**WALBERTON PARISH COUNCIL
INCLUDING FONTWELL AND BINSTED**

Re: Planning application WA/93/20/PL: Land East of Tye Lane, Walberton.

Walberton Parish Council wishes to register an objection to this application. We have the following concerns.

Appendix B
Traffic Flow Diagrams

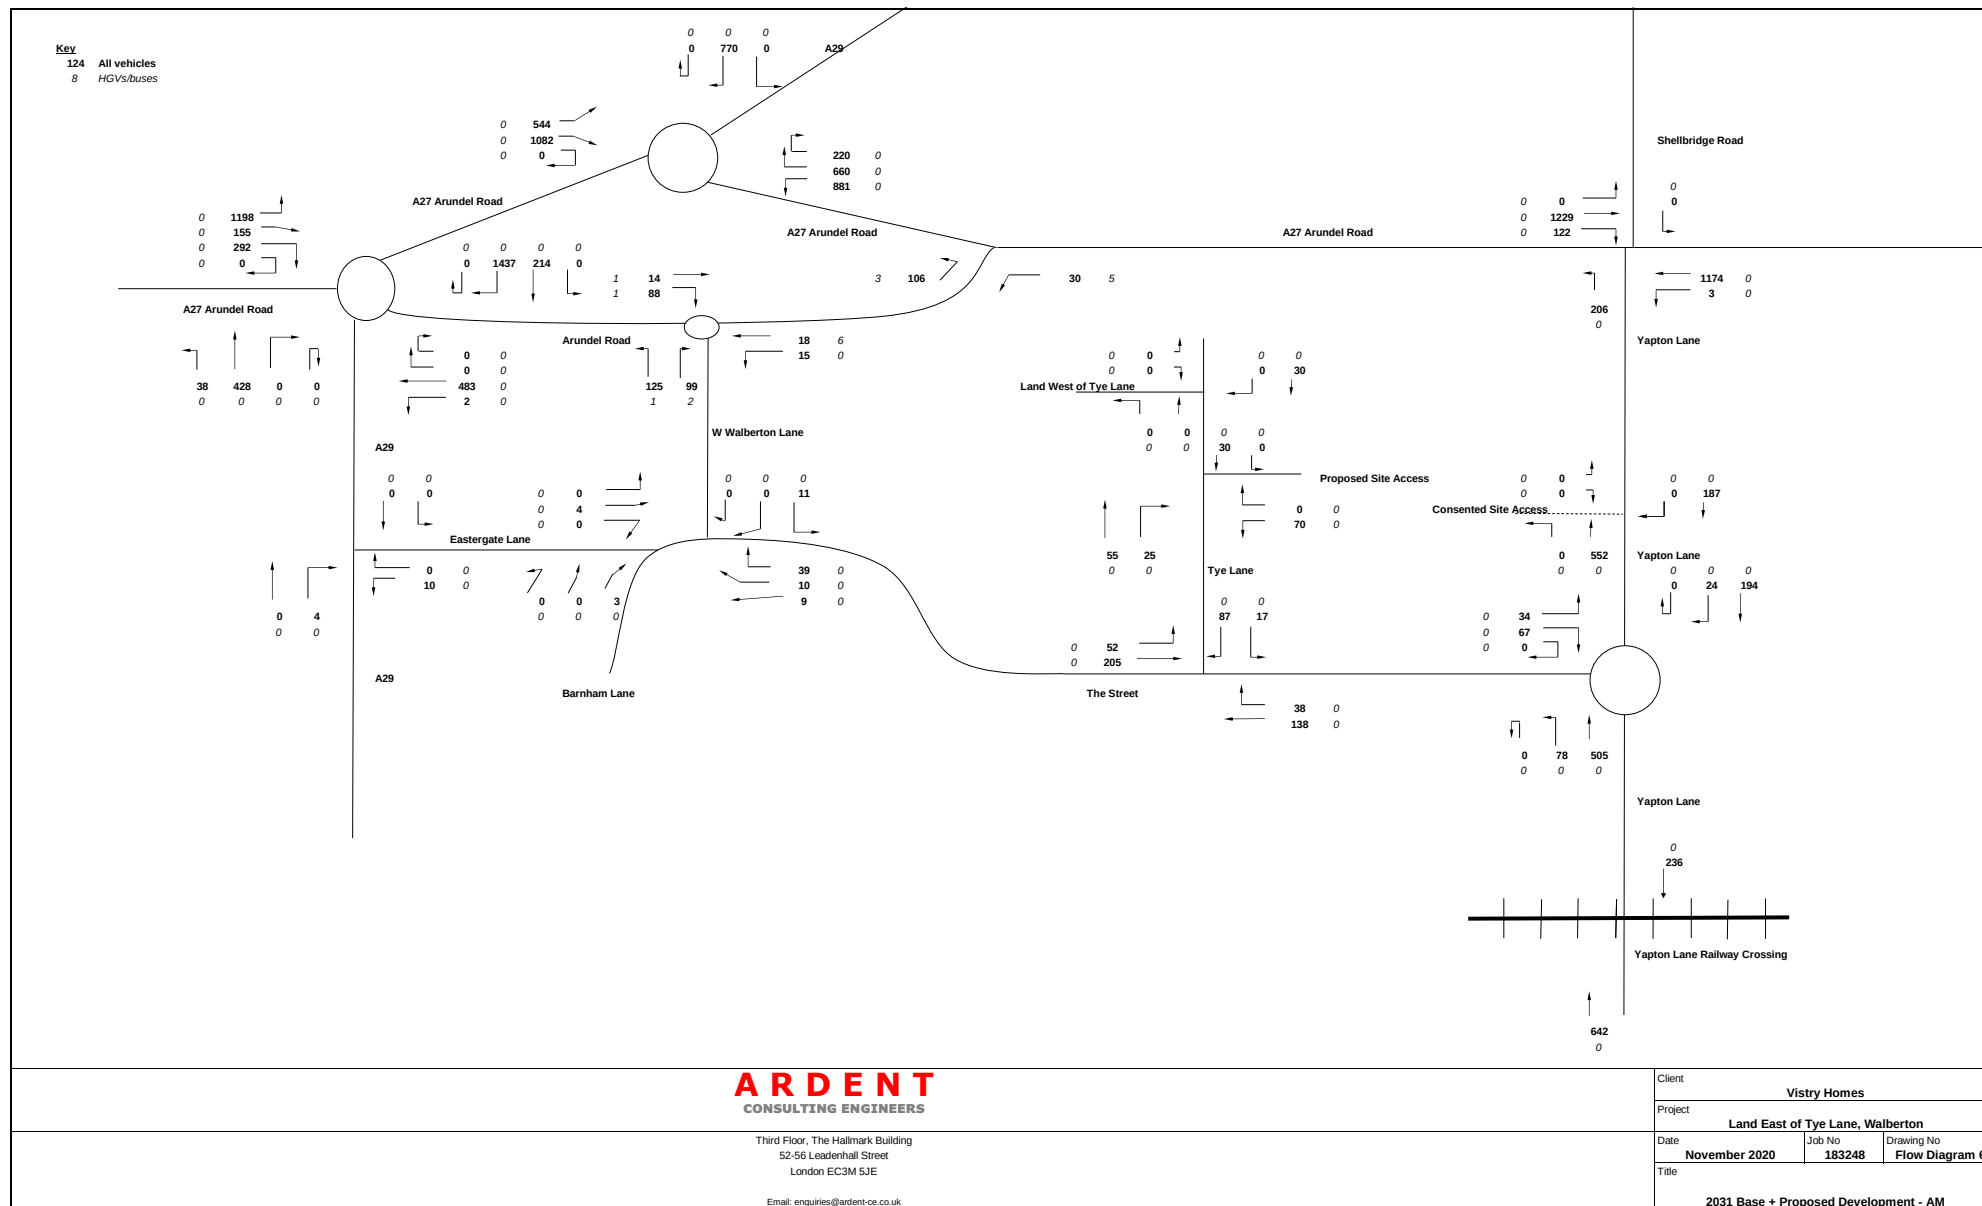
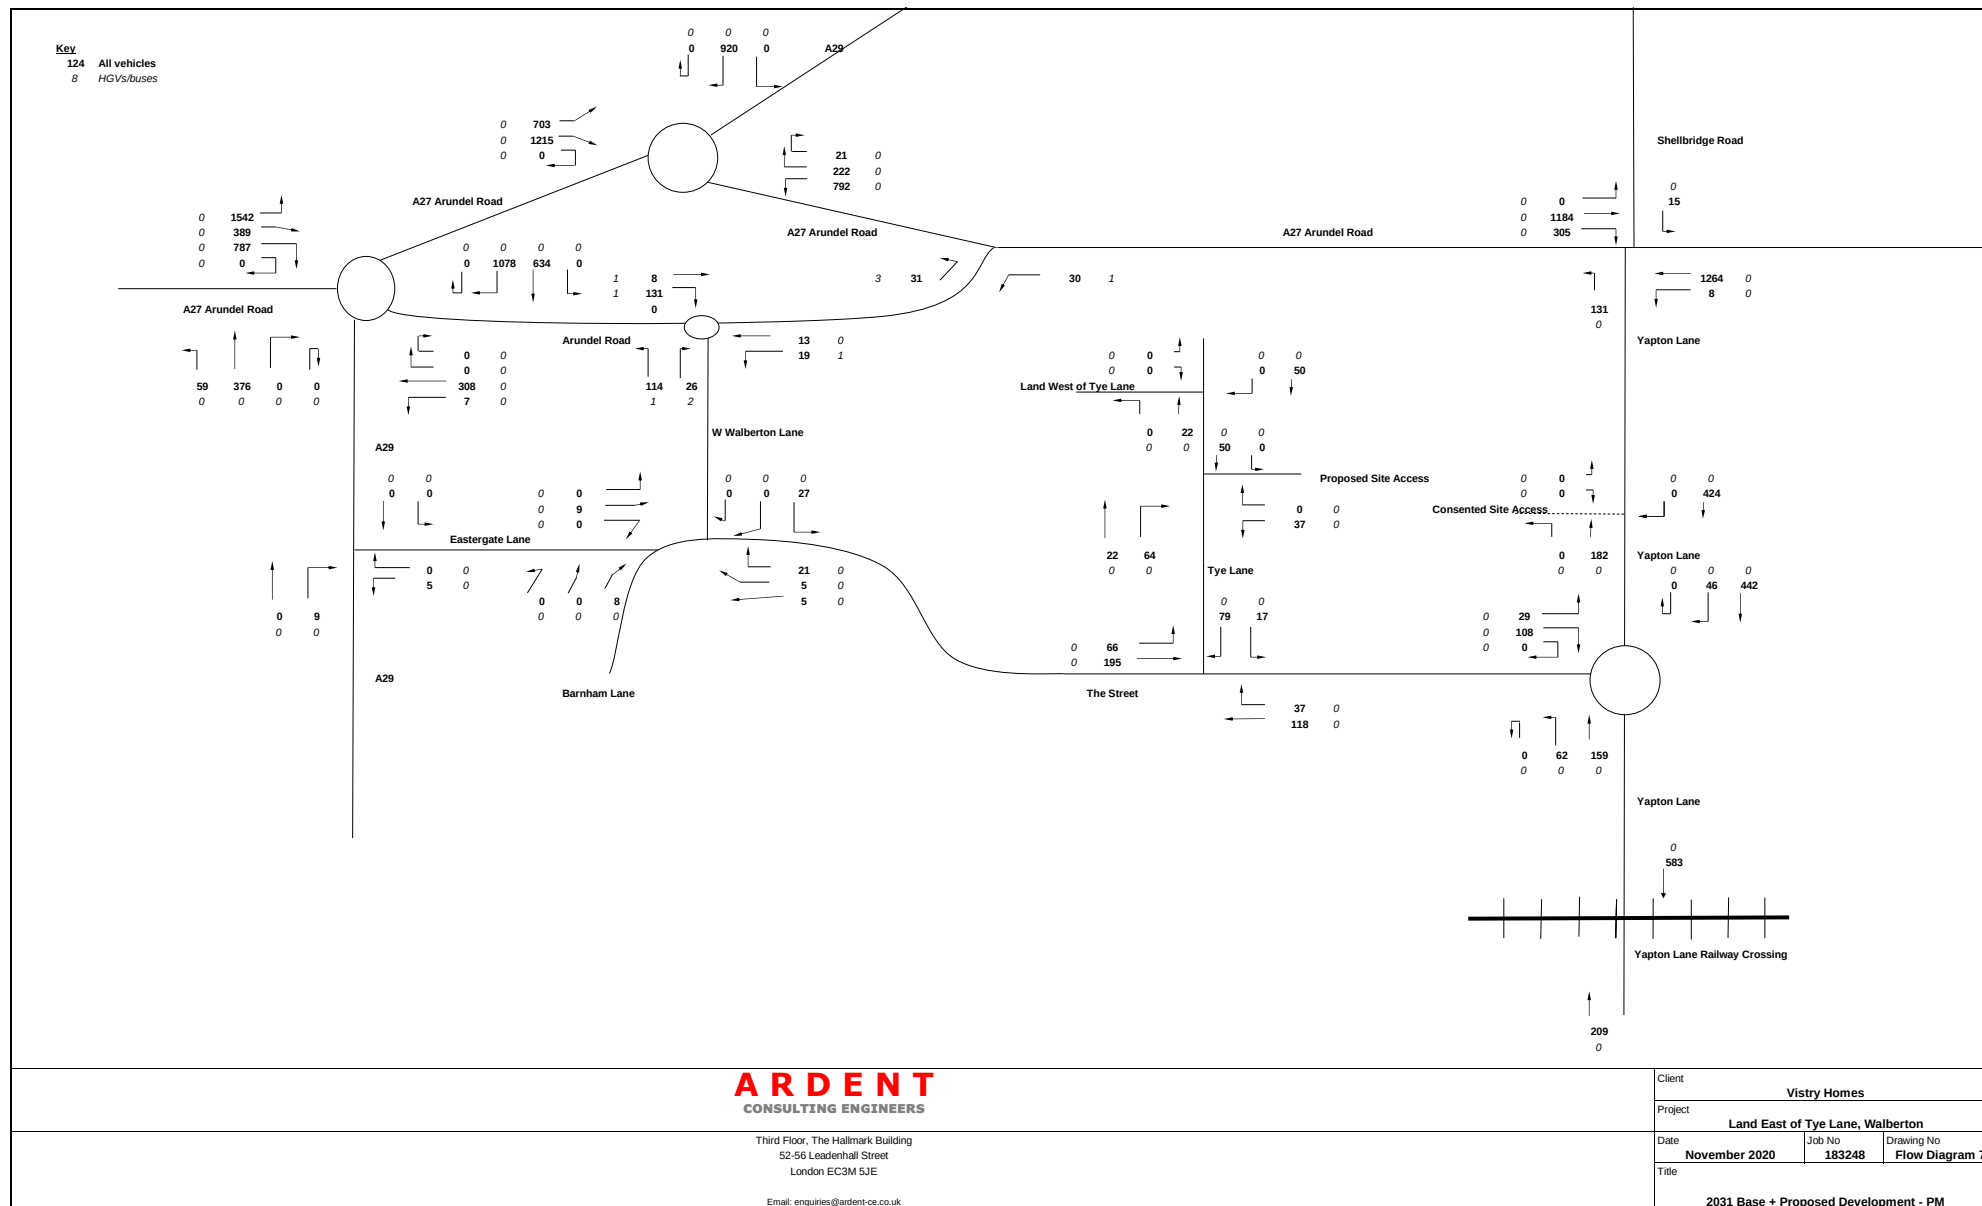
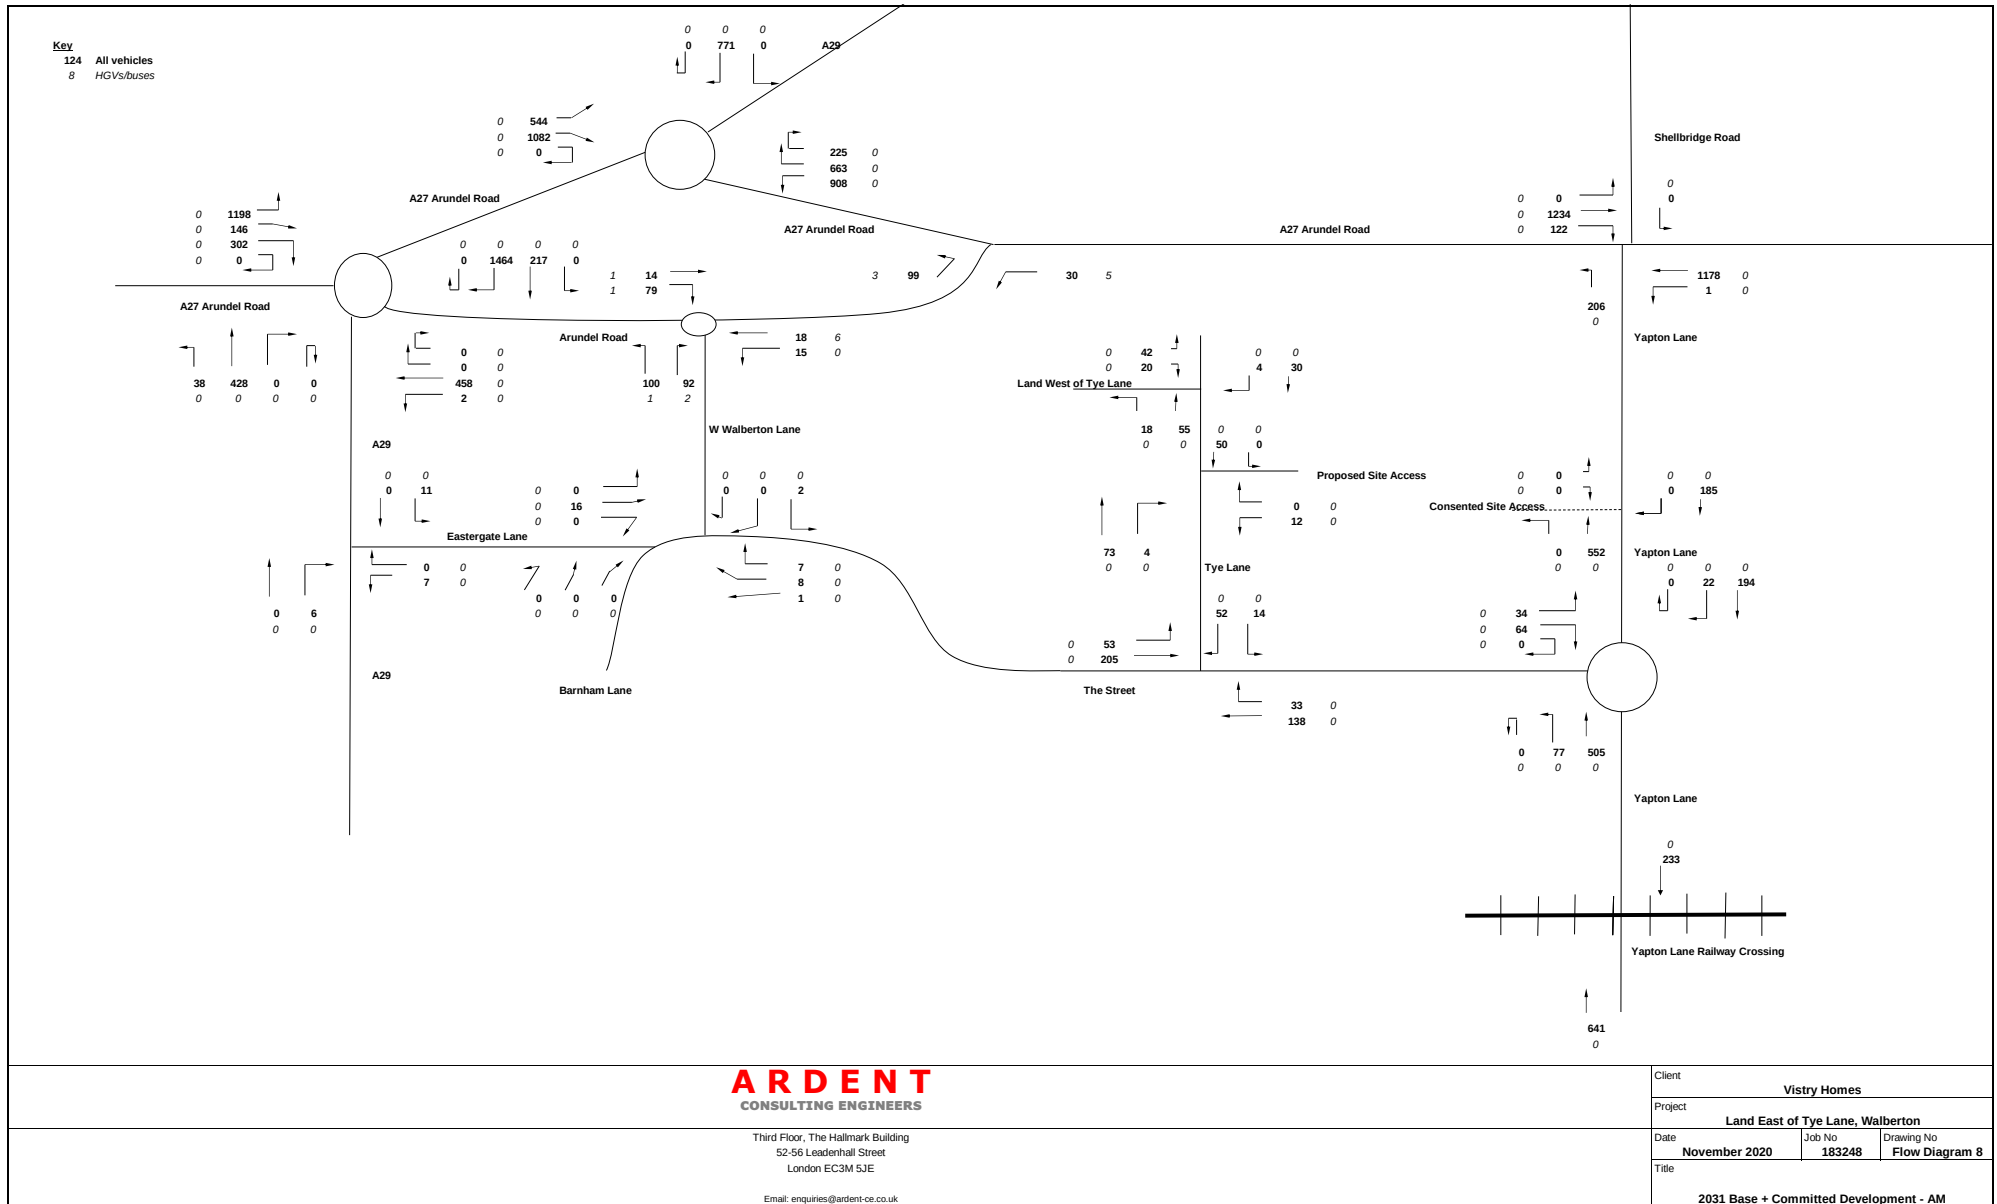
A number of Traffic Flow Diagrams are provided to illustrate changes in traffic flow patterns. However, they seem to have incorrect data.

The 2031 base numbers used refer to 50 vehicles going northwards up Tye Lane to a dead end and 30 heading southbound from this dead end. As there is no reason for this degree of traffic to head into a dead end, it appears that this reflects a prediction for travel when the road has not been severed by the A27. These numbers get added to the site traffic proposed flows to generate the reports for increased traffic after developments have been built, where no traffic heads up the dead end. We presume that no traffic is indicated heading North out of the development as the road is impassable.

Adding a base number for 2031 for traffic with a fully passable Tye Lane to a numbers post-closure for estate traffic as appears to have been done gives meaningless numbers. The 2031 base numbers for The Street, West Walberton Lane etc. will be incorrect if traffic has been allocated to Tye Lane and the A27 where it cannot go so will falsely reduce the numbers for our local roads. This will give a reduced indication of the real impact of the traffic to the local roads.

- There would appear to be very few vehicle users predicted for 175 (soon to be 205) dwellings. For example, the base traffic and additional from proposed developments indicate 70 movements leaving in the am peak, and 6 returning in the pm peak. Assuming only two residents per dwelling and all movements to be due to the Avisford Grange development suggests only 17% of residents (70 movements out of 410 residents) will travel during peak times to work or school.
